From: Clerk Yapton Pa
Sent: 08 August 2011
To: Janice Chapman
Subject: Planning Application Y/35/11/L

Y/35/11/L - CLARIFICATION SOUGHT

PROPOSED CROSS SECTION A : A 1/50

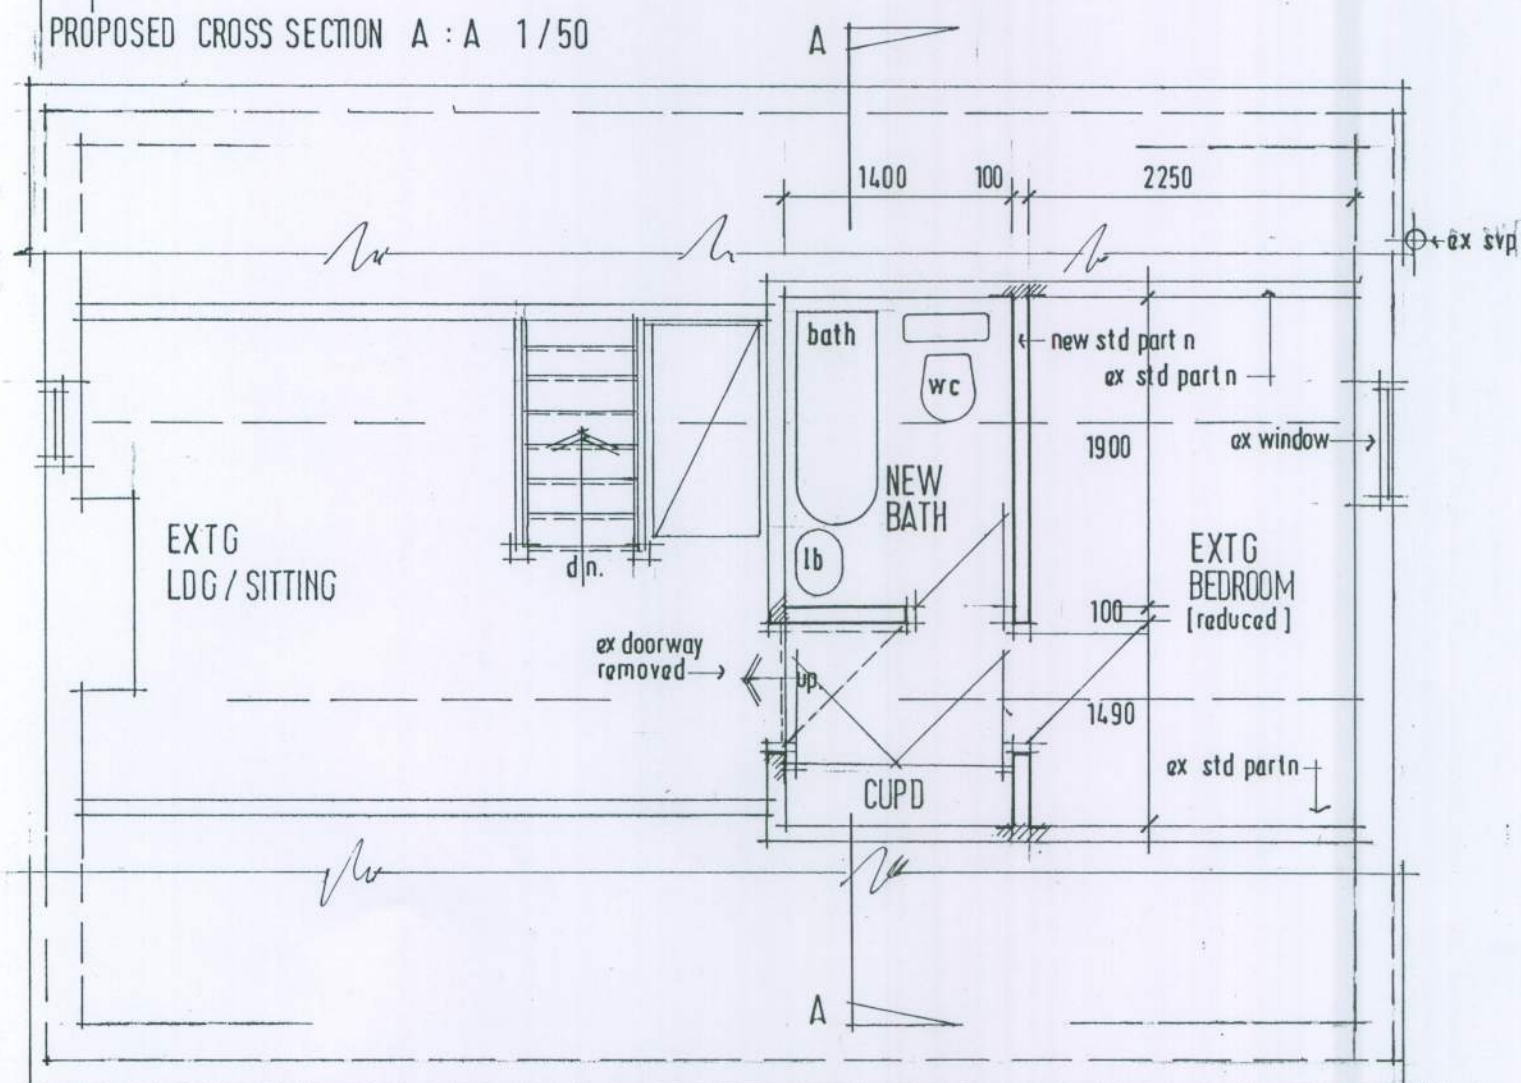
The bathroom has no ventilation or window. Will ventilation be provided and where will it exit, through the roof or walls? In the Parish Council opinion this requires investigation or a statement from the Agent.
